CITY OF PORTLAND

BUILDING PERMIT

Located At 15 ALLISON AVE

has permission to build a new single family residence with an attached garage.

Project Name:	Contractor:	Drawn By:
Hights	Construction System of New England	Crystal Bourassa Date: October 1, 2012 Revised: November 2, 2012

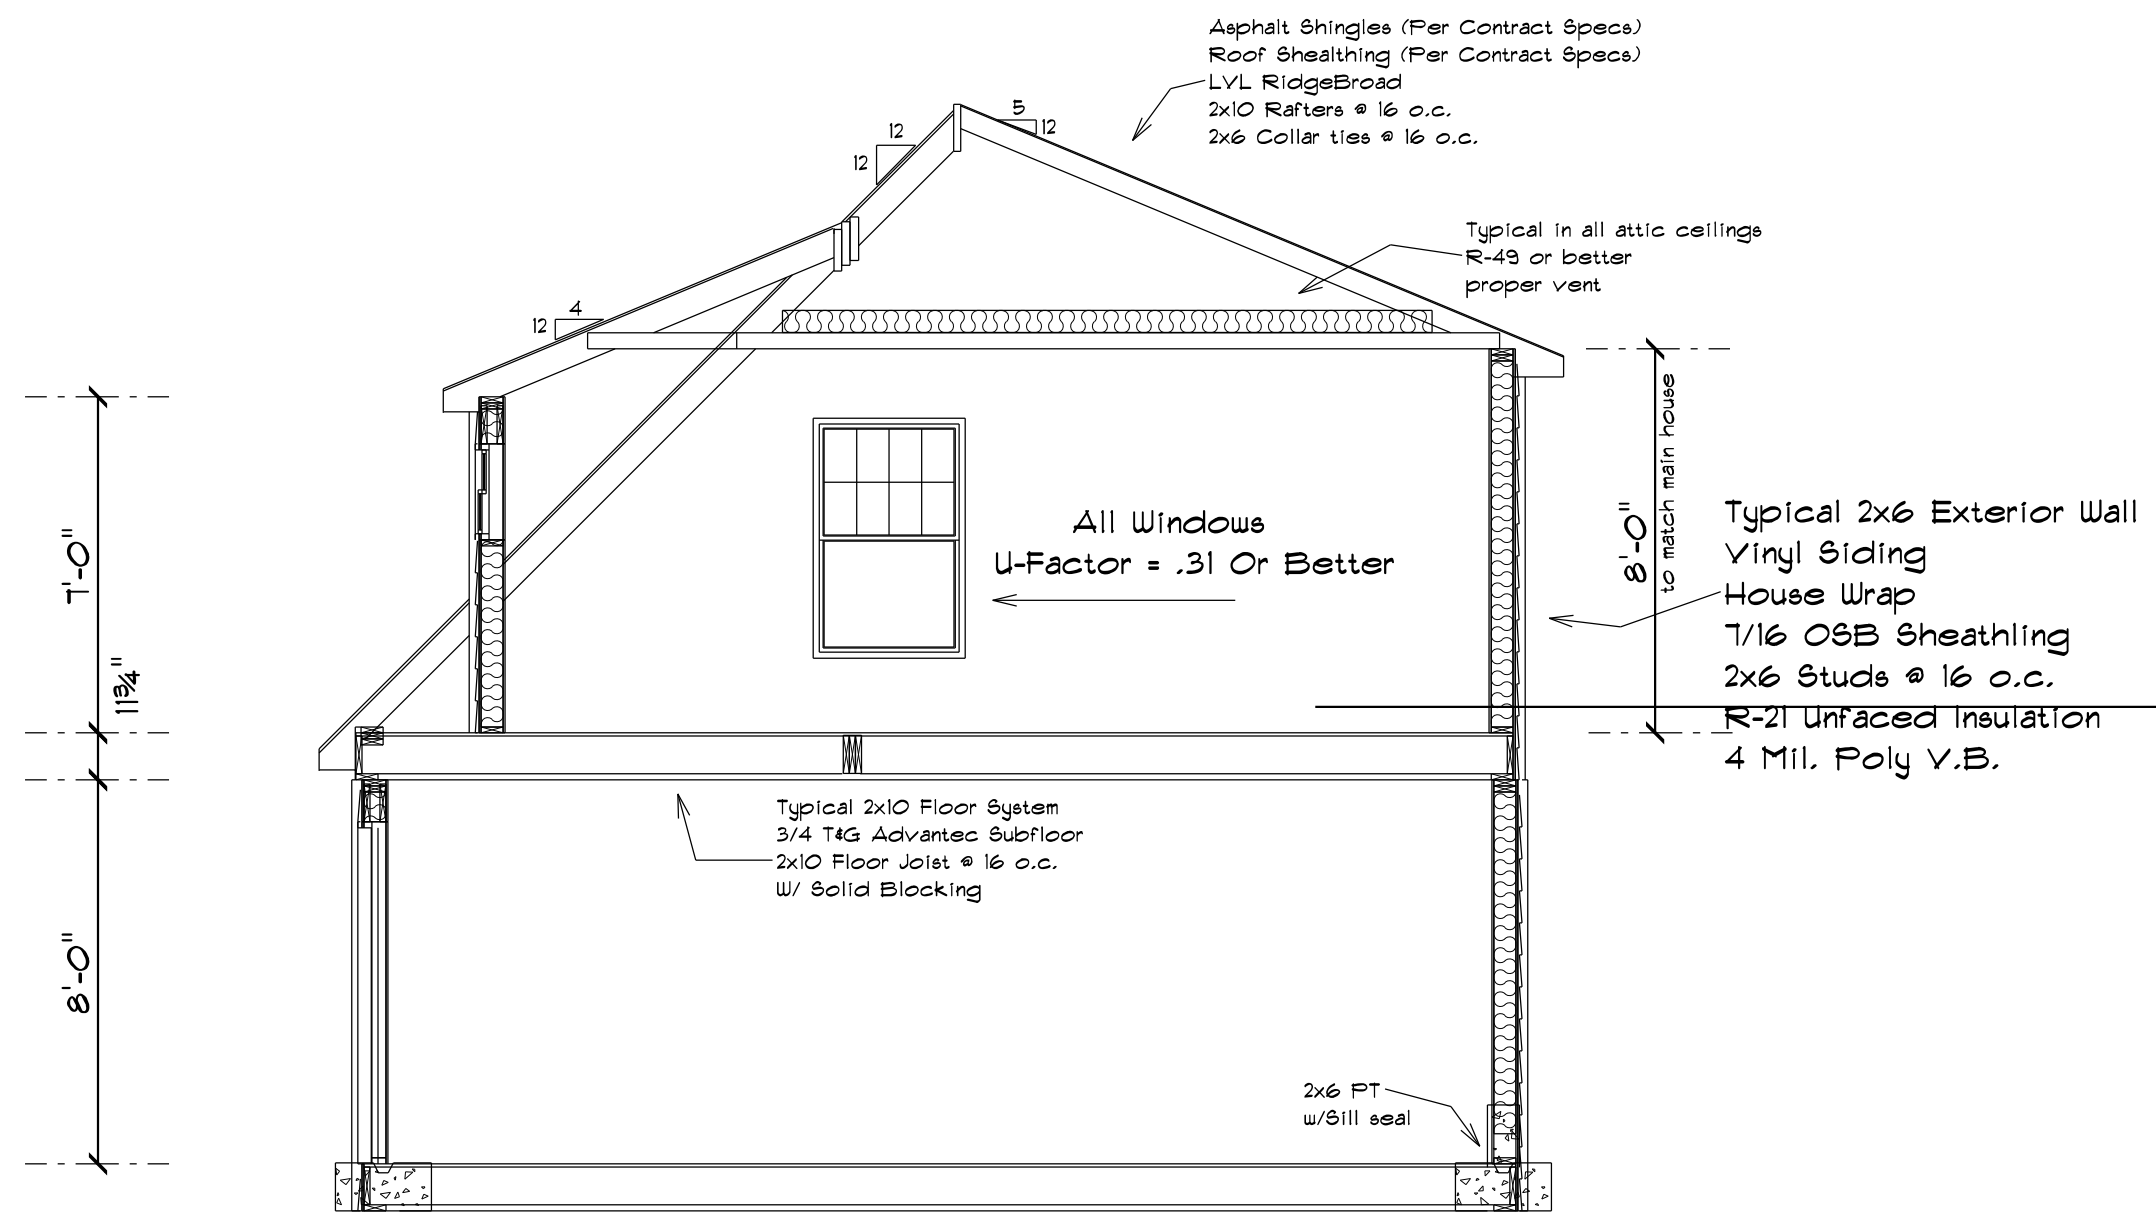
The information below was missing on the building permit application. The floor framing plans/ cross sections need to indicate the (3) 2 x 12 girder spans/ spacing between each lally column; the roof framing plan must show how the dormer meets the 2 by 10 inch rafters, with finished headroom. All bulleted items require a response for permit issuance.

- Footing Dimensions/Depth 20" x 10"
- (Table R403.1 & R403.1(1), (Section R403.1 & R403.1.4.1)
- Foundation Drainage, Fabric, Damp proofing Indicated in the cross section but not spelled out. Also clearly shown in the drainage design
- (Section R405 & R406)
- Ventilation/Access (Section R408.1 & R408.3) shown in cross section at eaves with propa vent and ridge vent at peak
- Crawls Space ONLY
- Anchor Bolts/Straps, spacing (Section R403.1.6) Bolts at 6' o.c.
- Girder & Header Spans between lally columns? (Table R 502.5(2)) on foundation plans
- Built-Up Wood Center Girder shown in cross section

- **Dimensions and Spacing** (Table R502.3.1(1) & Table R502.3.1(2))
- Attic or additional Floor Joist Species
- Dimensions and Spacing (Table R802.4(1) and R802.4(2))
- Dormer pitch, Span, Spacing & Dimension (Table R802.5.1(1) - R 802.5.1(8)) shown in cross section

- **Roof Rafter; Framing & Connections (Section R802.3 & R802.3.1)**
 - **Rafter tie connection to top plate?** not shown but I use H2.5 hurricane clips
- **Fastener Schedule (Table R602.3(1) & (2))**not shown
